City of Albuquerque

CERTIFICATE OF COMPLETION AND ACCEPTANCE

RE: PROJECT NO. 4729.82 RIDGEFIELD NORTH PHASE II (MAP NO. D-20-Z)

RE: GRADING PLAN FOR RIDGEFIELD NORTH SUBDIVISION UNIT 2 (D-20/D8A)
RECEIVED JULY 1, 1993 FOR ROUGH GRADING PERMIT APPROVAL
ENGINEER'S STAMP DATED 6-26-93

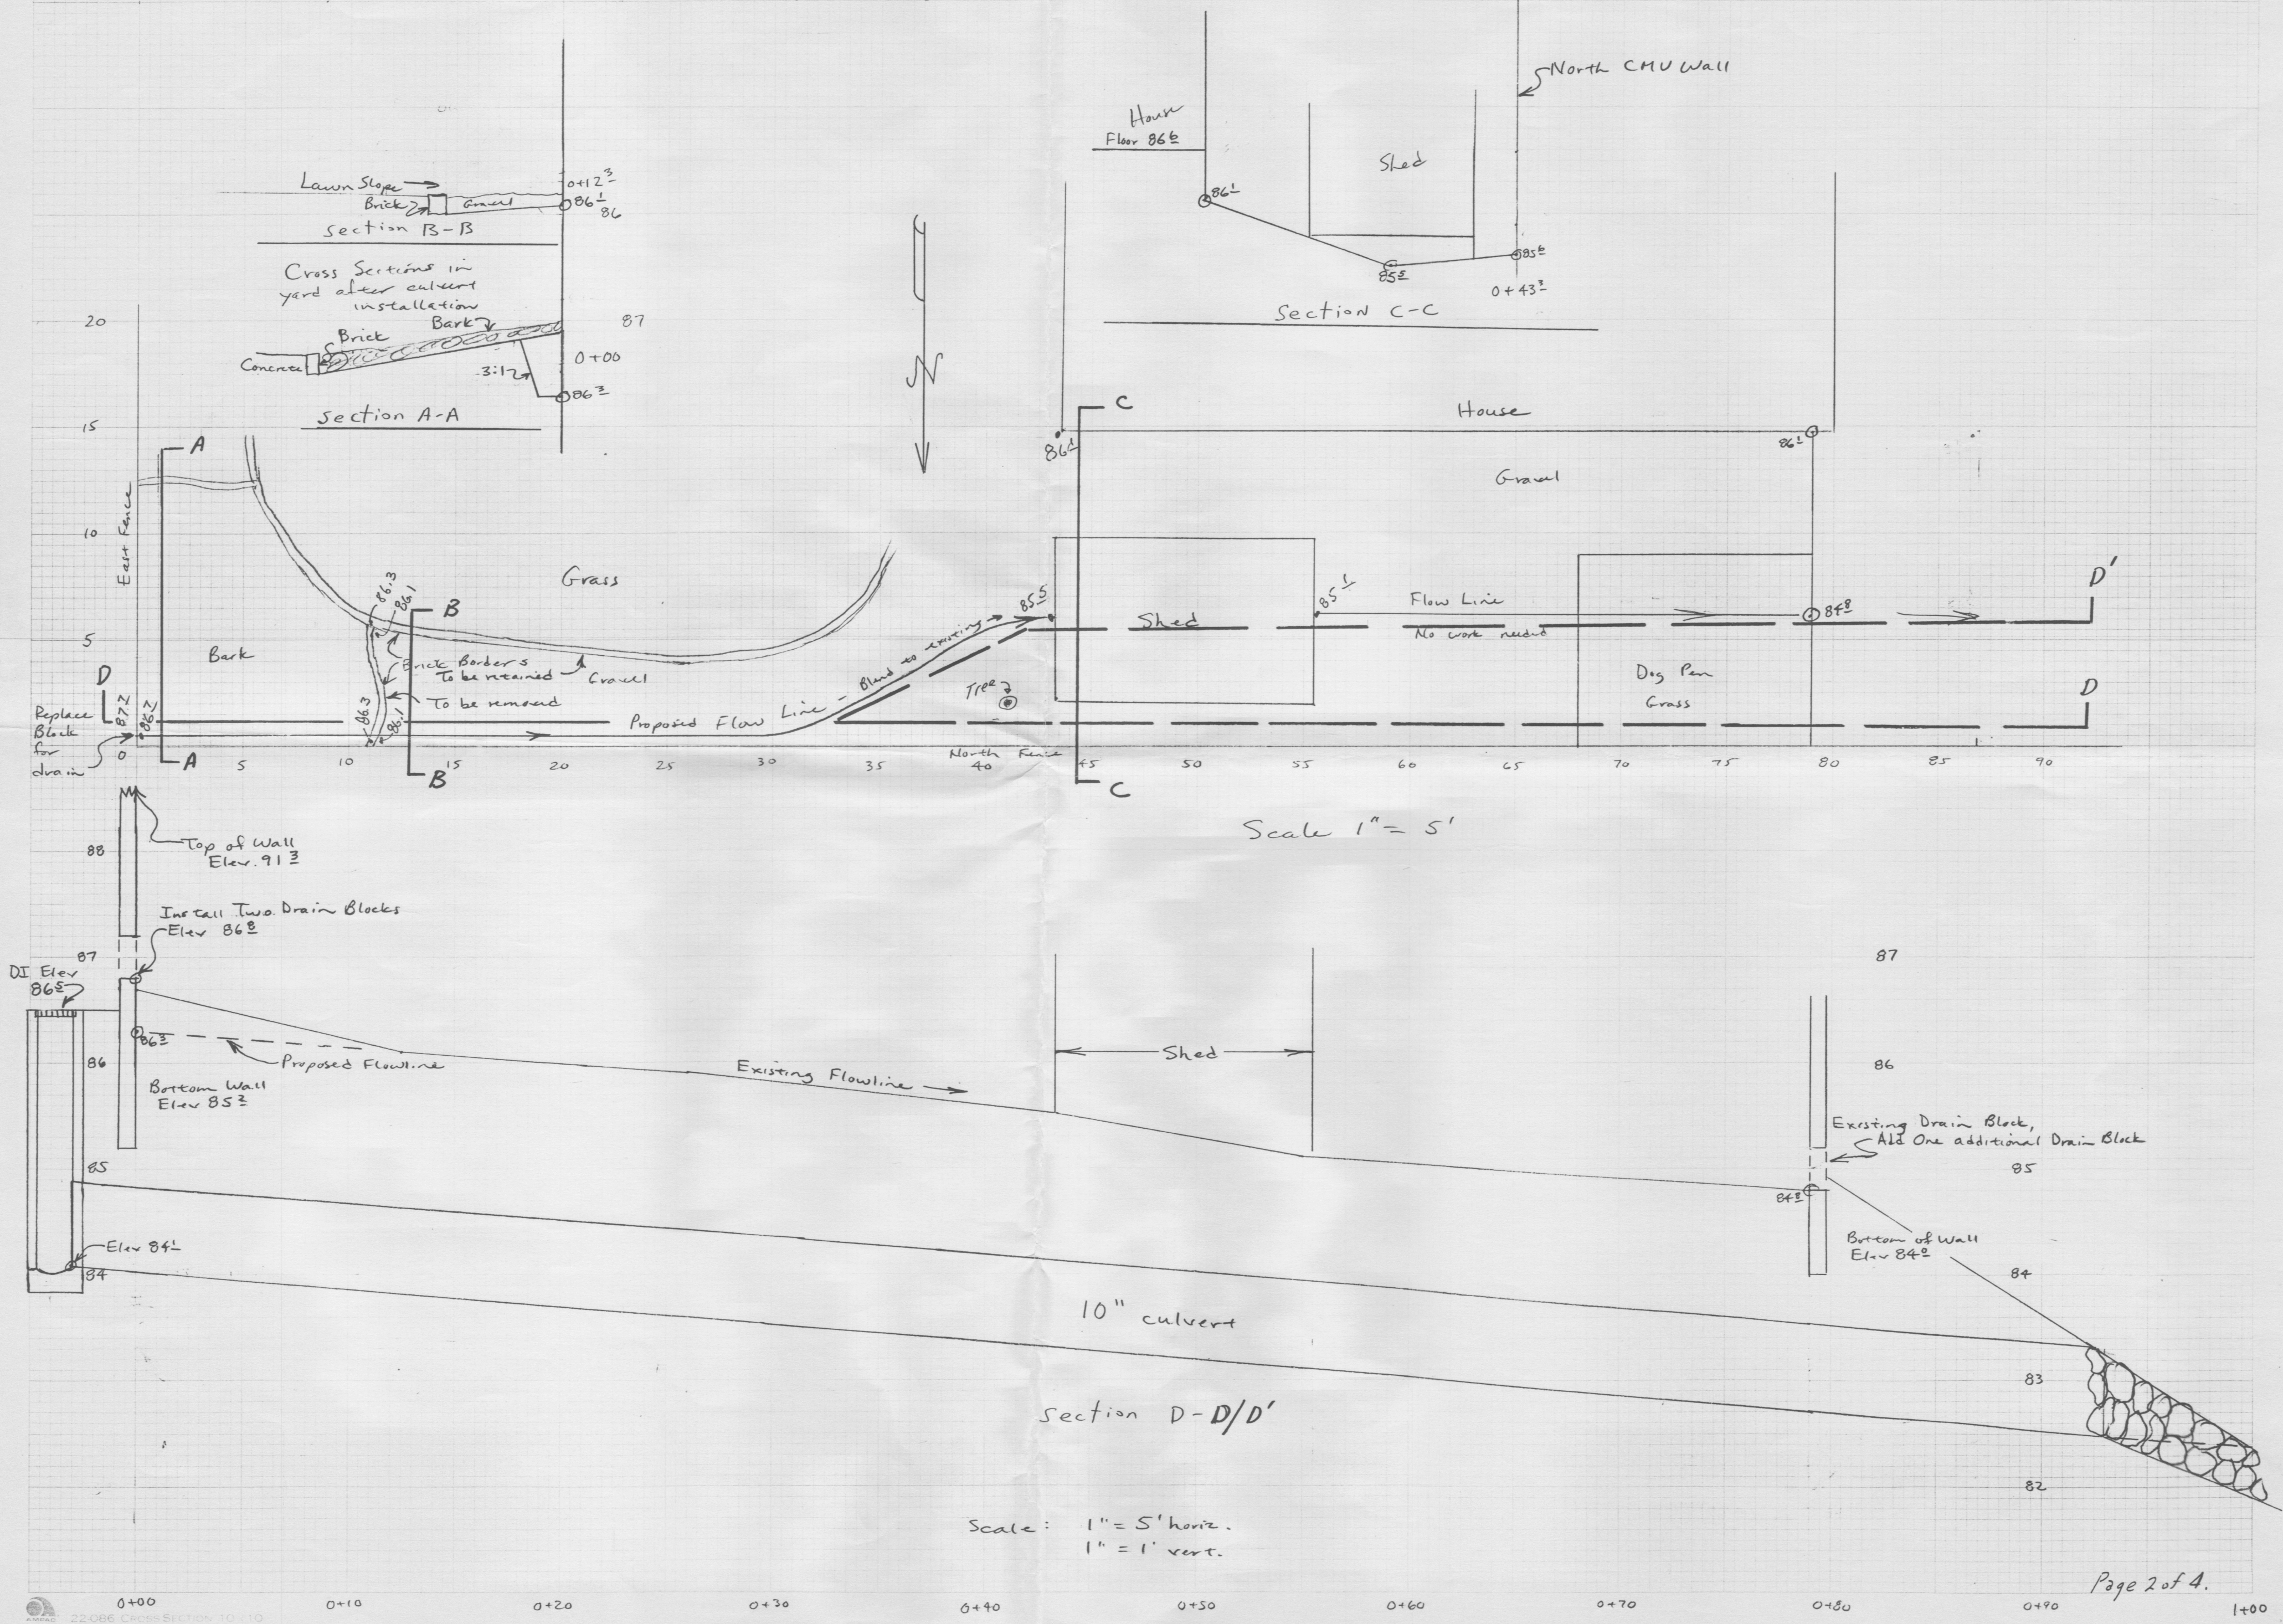
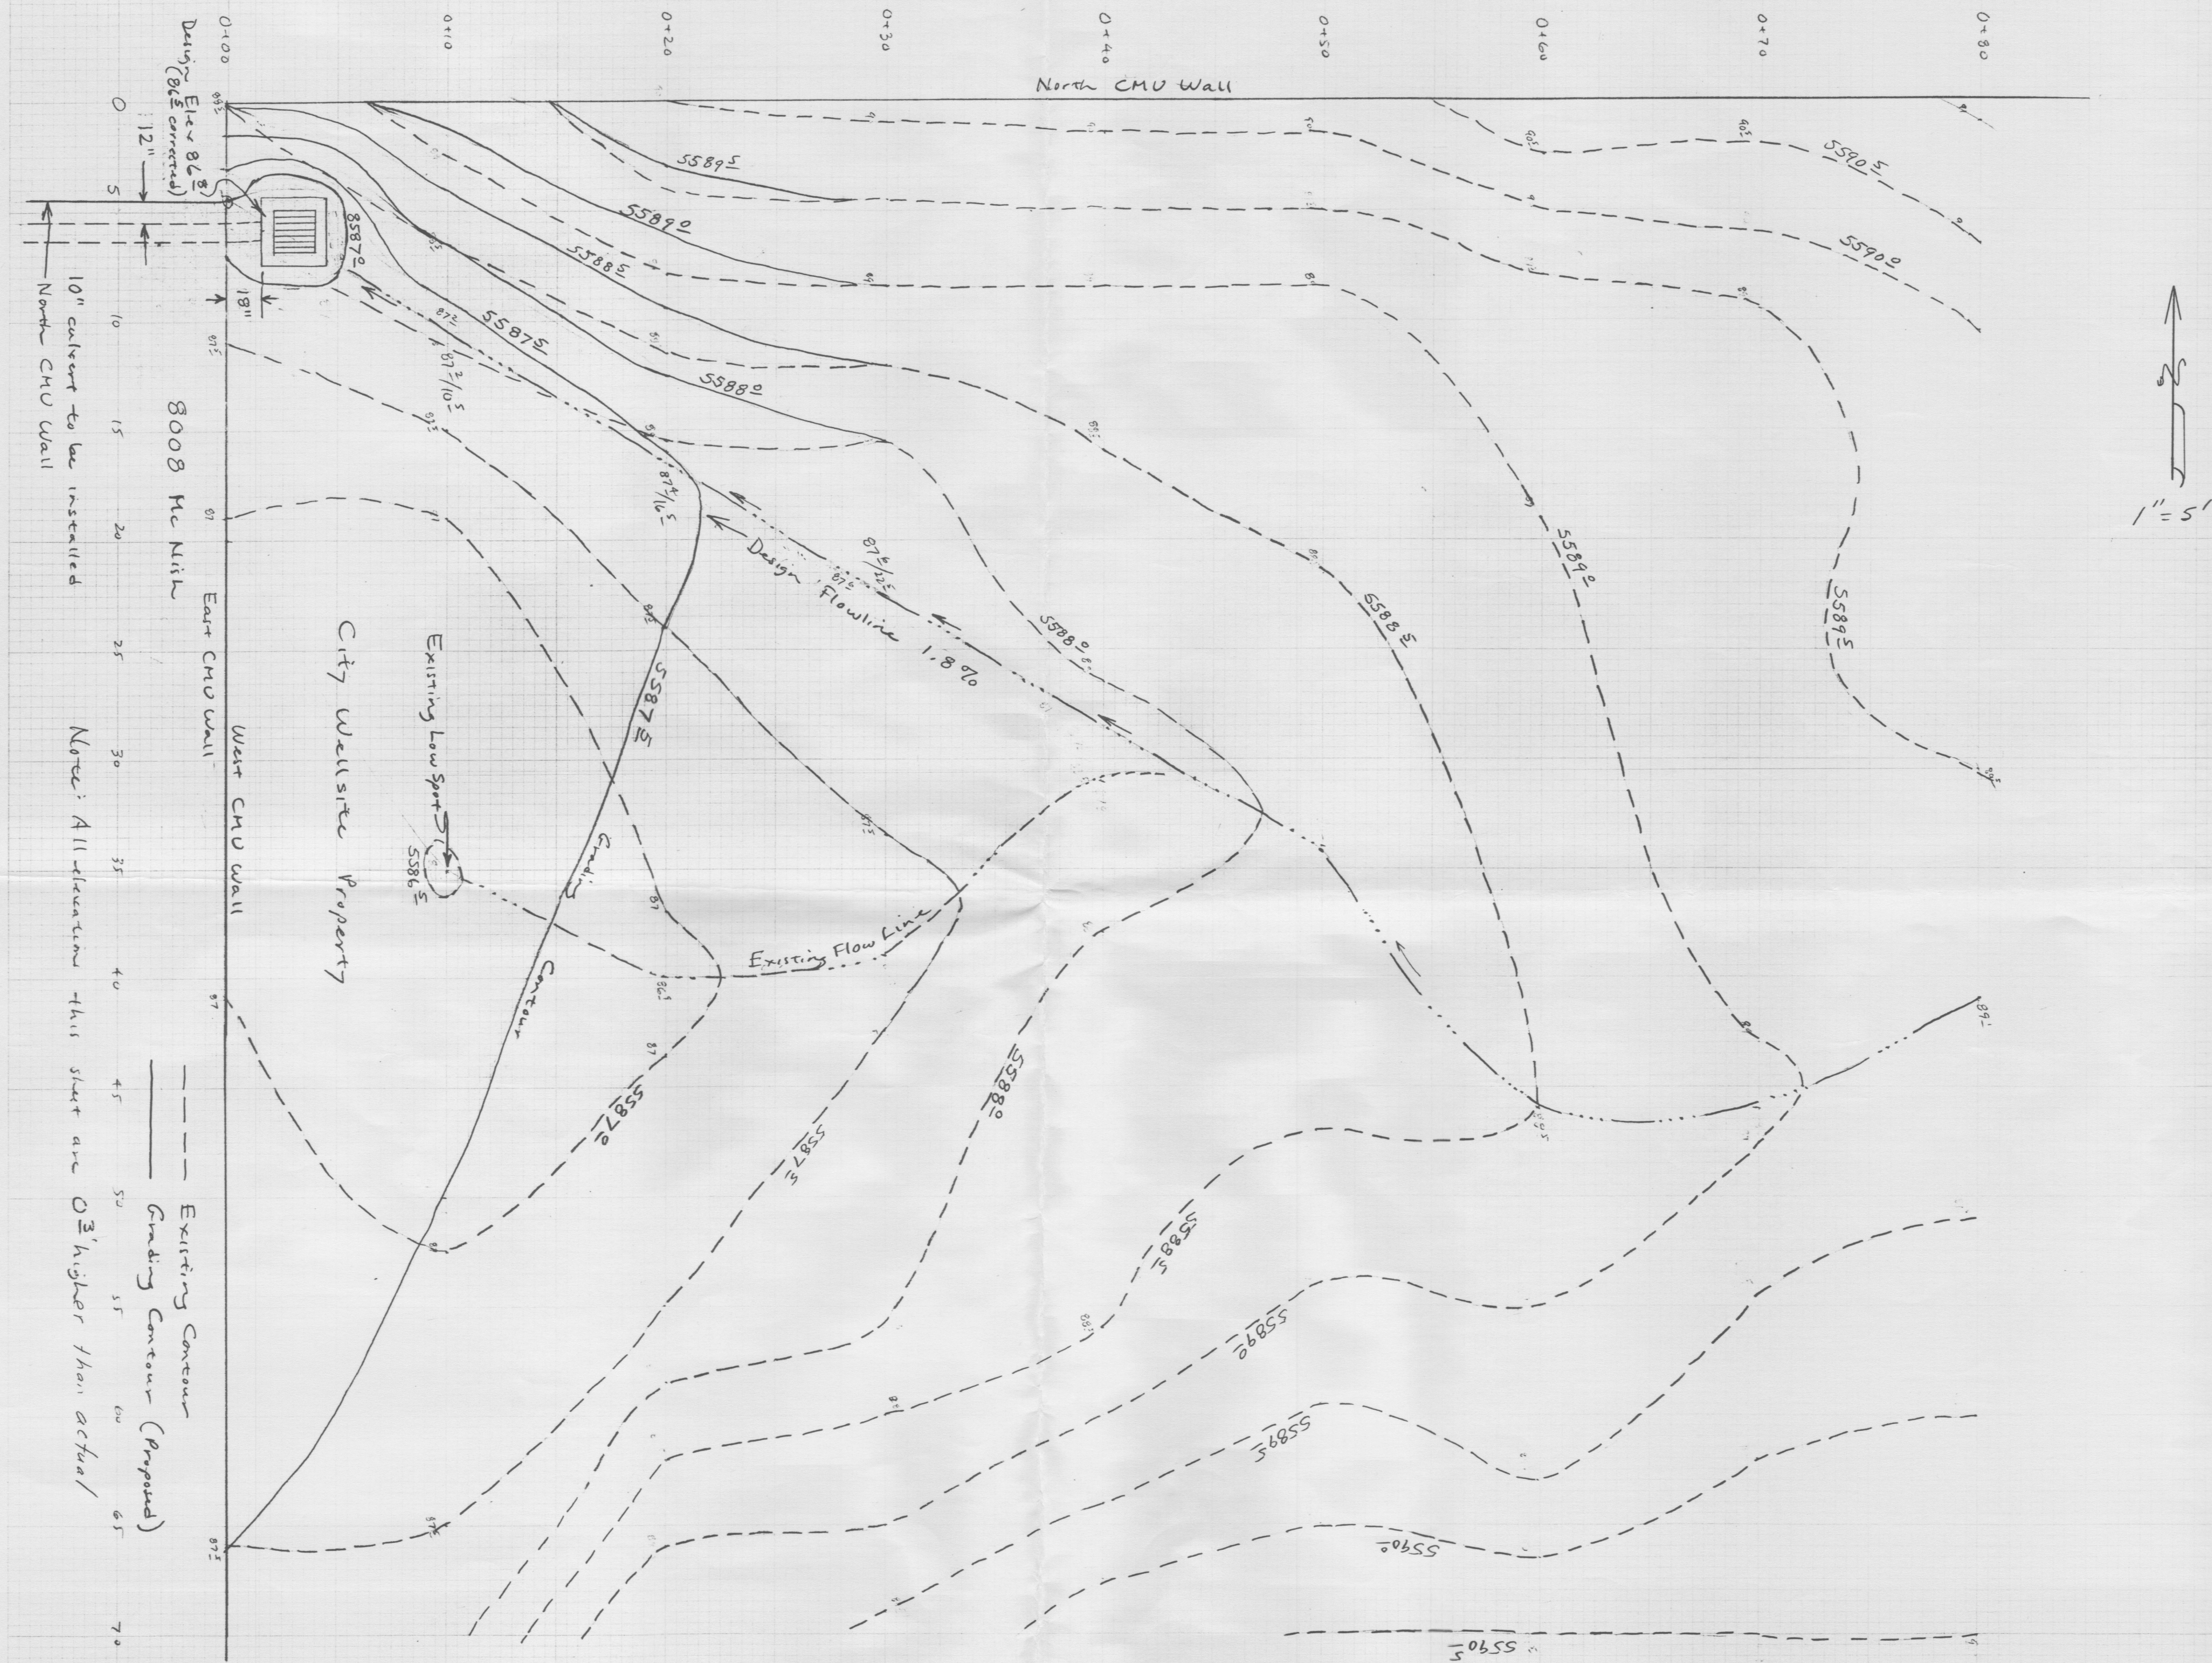
Check the proposed spot elevations between lots 6 & 7, and 87 & 106. There maybe drafting errors on lots 22 & 80. None of these should hold up rough grading.
